PROJECT TITLE: HOLIDAY INN EXPRESS ZONE ATLAS/DRNG. FILE #: L-16/10230

RE: GRADING REVISION APPROVAL FOR HOLIDAY INN EXPRESS (L-16/D23B) ENGINEER'S
STAMP DATED 9/13/94

RE: CONCEPTUAL DRAINAGE PLAN FOR HOLIDAY INN EXPRESS (L-16/D23B) ENGINEER'S
STAMP DATED 2/24/94

GRADING AND DRAINAGE PLAN FOR THE HOLIDAY INN EXPRESS TRACT 6A, CAVAN SUNPORT CENTRE ALBUQUERQUE NEW MEXICO MAY, 1994

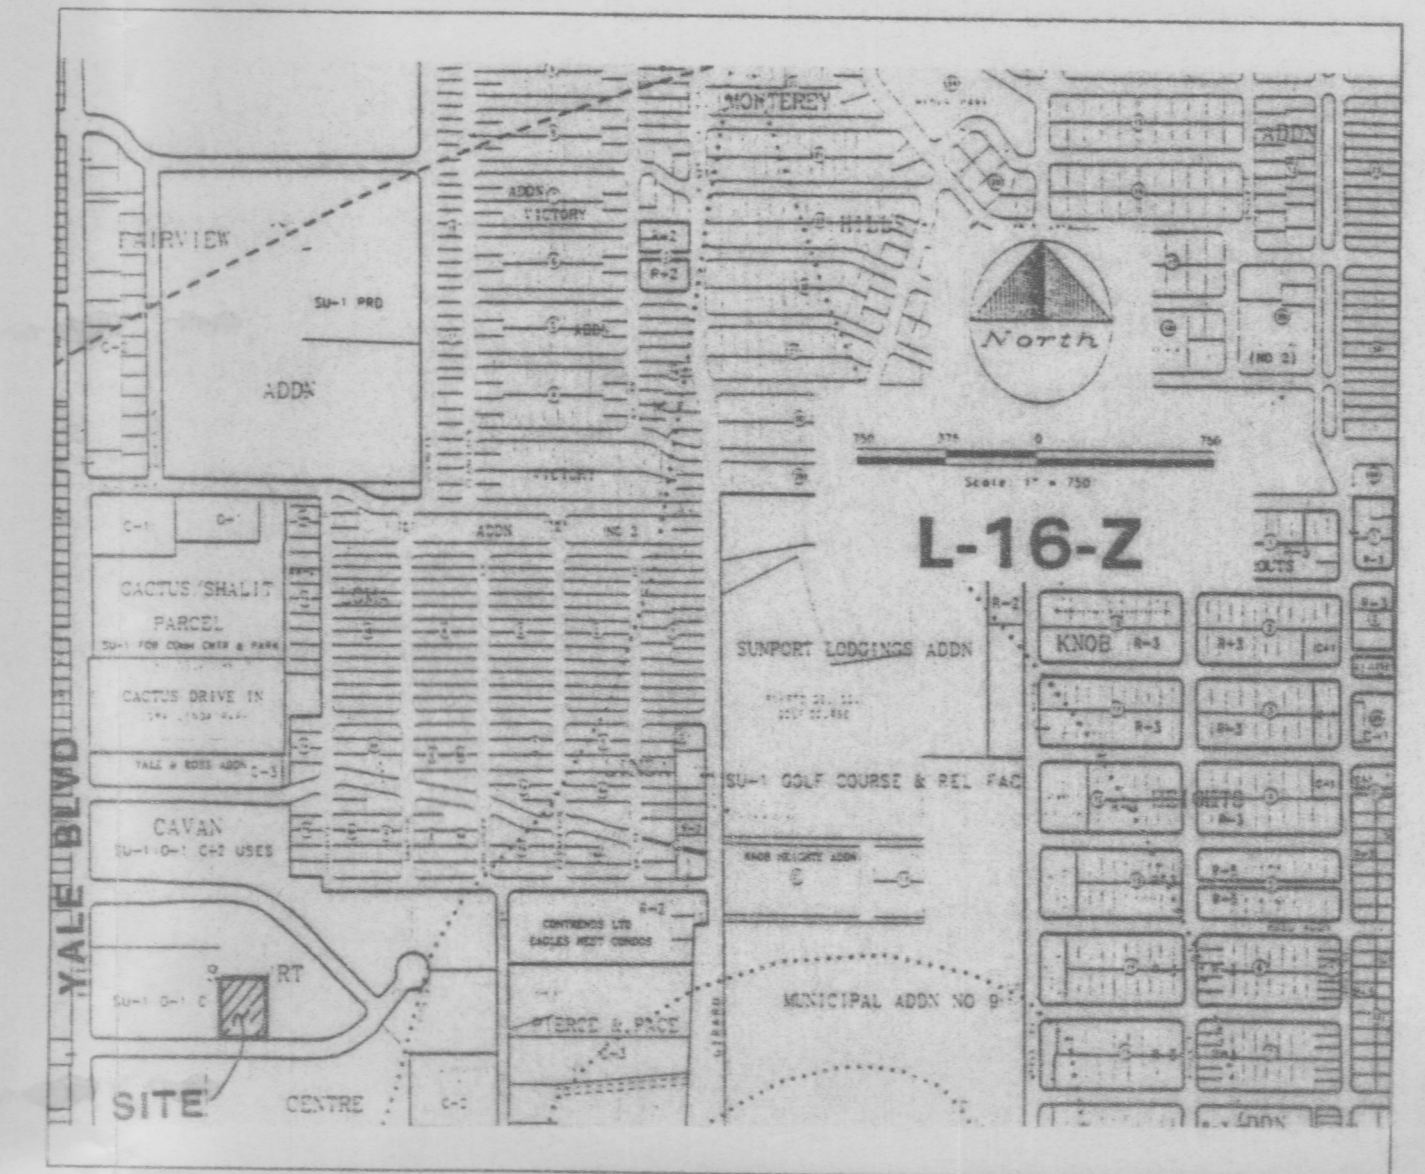
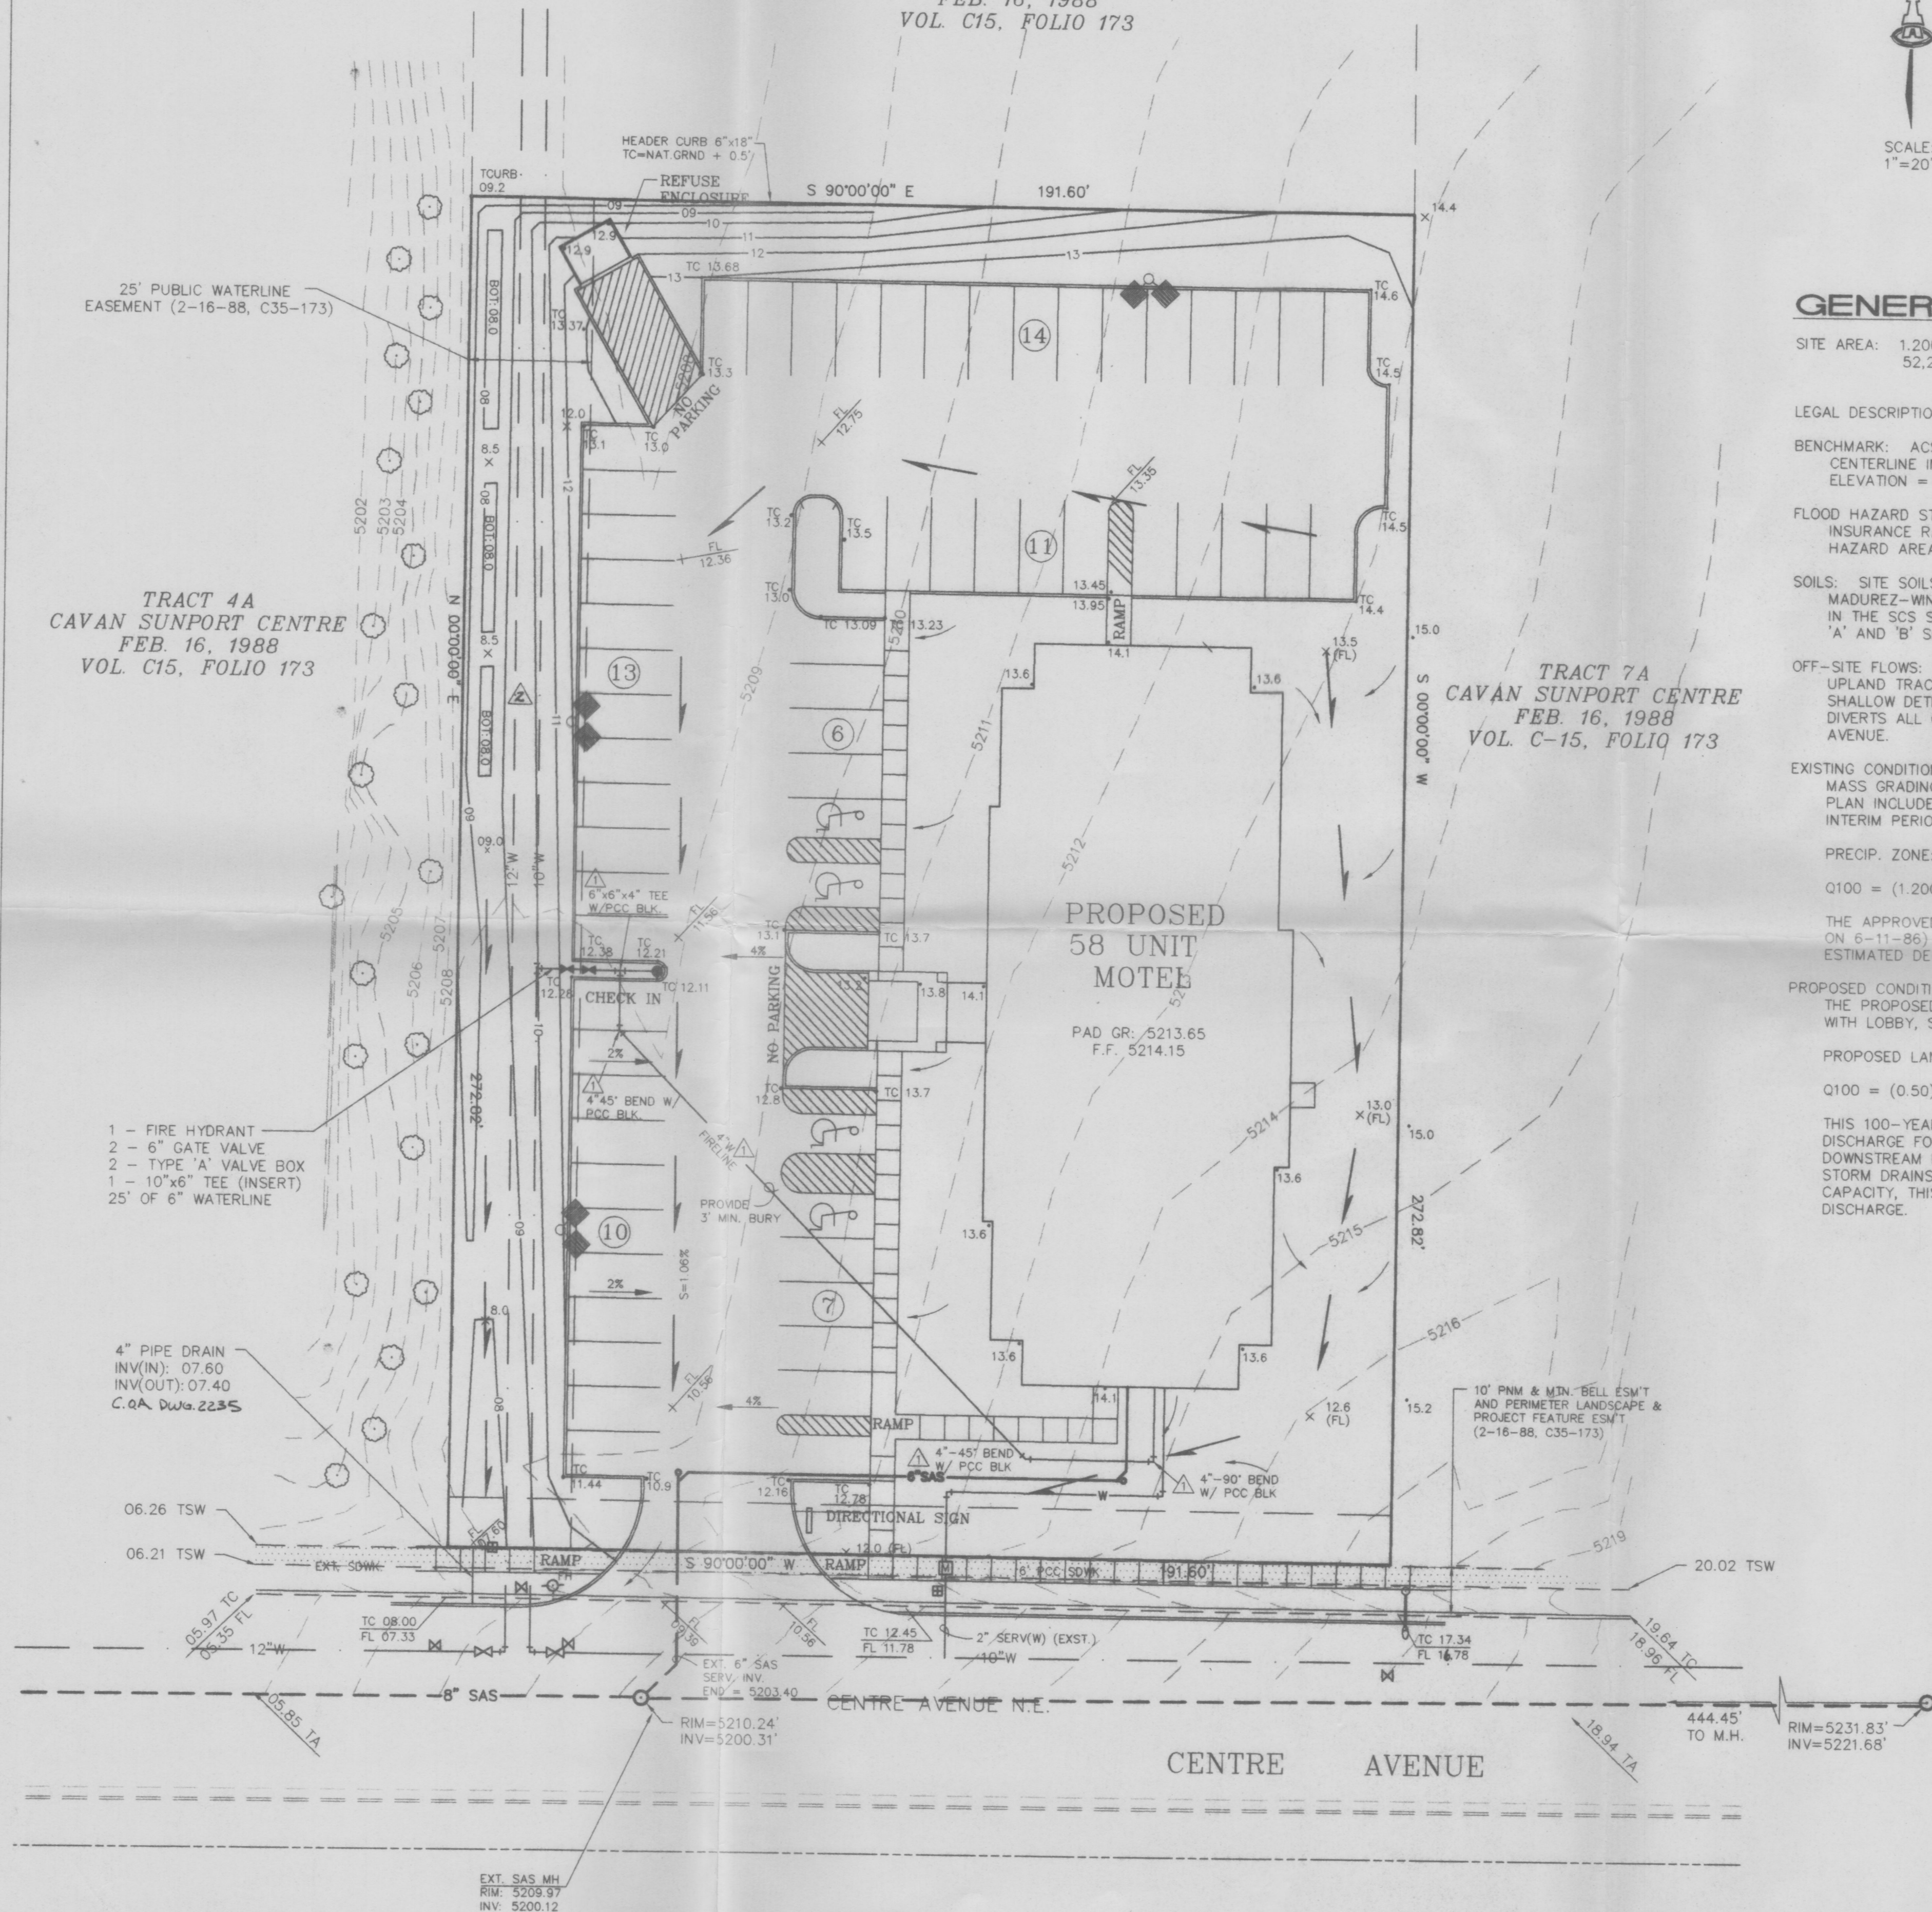
The revision to the grading plan, submitted to this office on 9/22/94, appears acceptable. Although permanent retention ponds are not typically allowed, since the ponds you show will accept only a small amount of flow from solely the landscaped area, it can be allowed.

Since the north side of the site falls onto the adjacent property, it is essential that the header curb is constructed along that property line. In addition, please verify that the top of curb is at least 6" above finished grade as you specify on the plan.

CONCEPTUAL GRADING AND DRAINAGE PLAN TRACT 6A, CAVAN SUNPORT CENTRE ALBUQUERQUE NEW MEXICO FEBRUARY, 1994

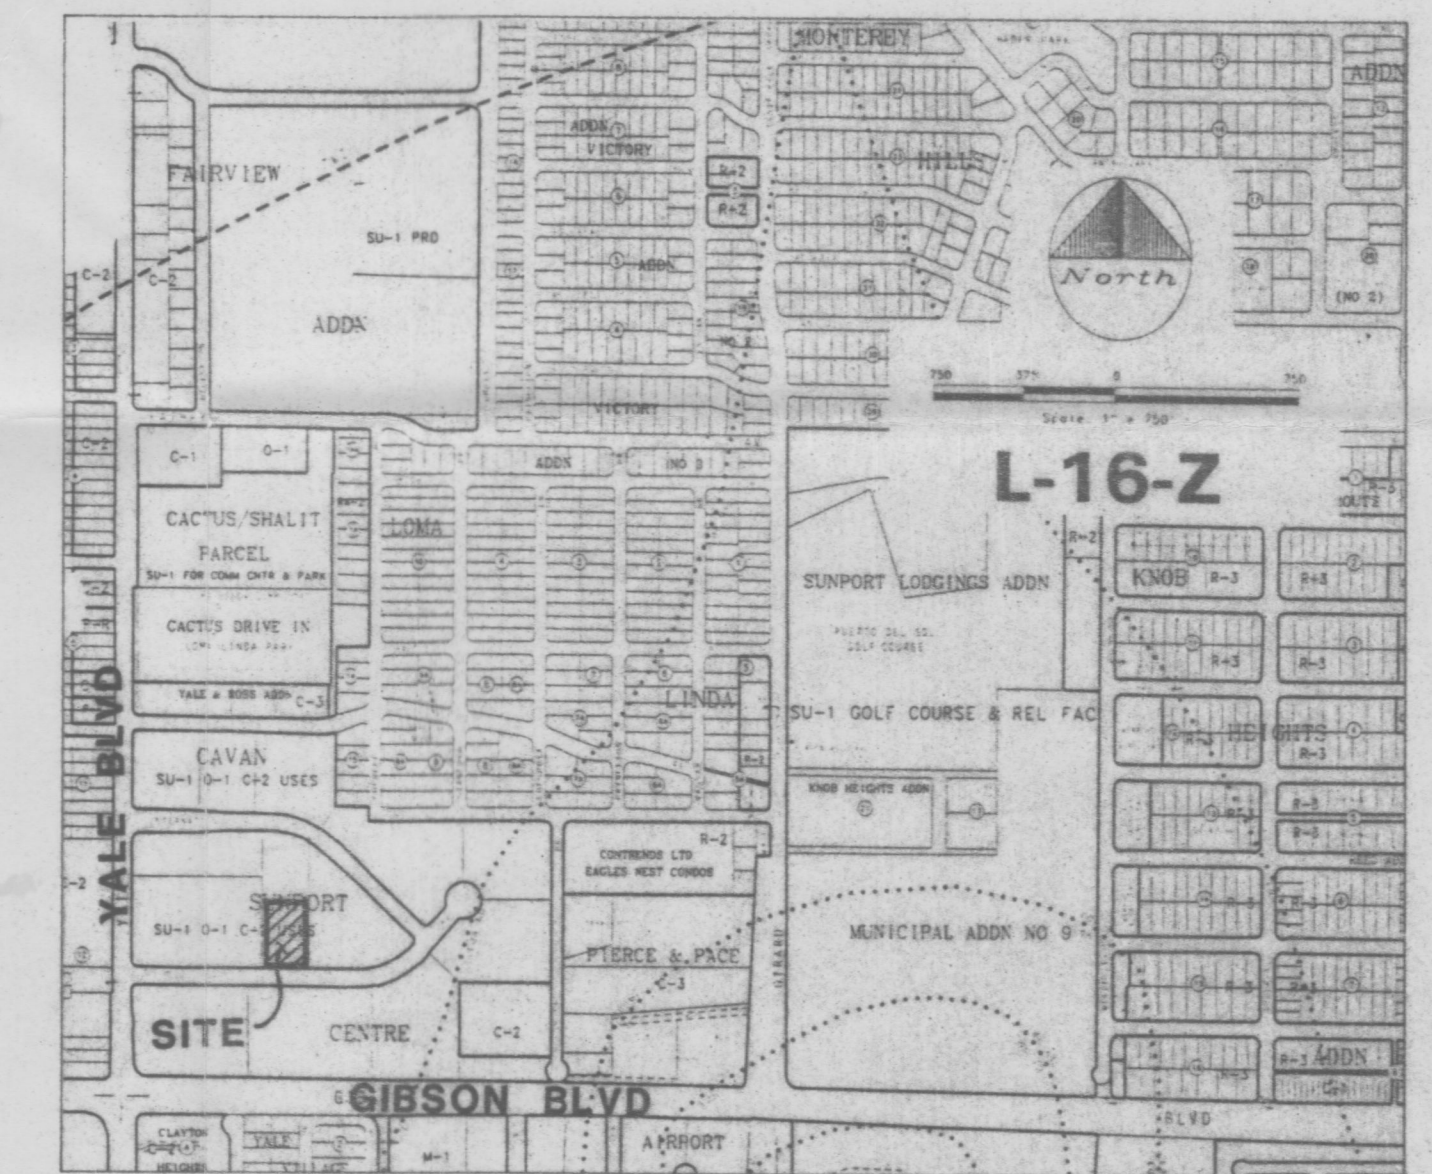
Based on the submittal received by this office on 3/16/94, Site Development Plan approval is granted at this time. Please note on the plan drawing that prior to Certificate of Occupancy release, Engineer Certification will be required.
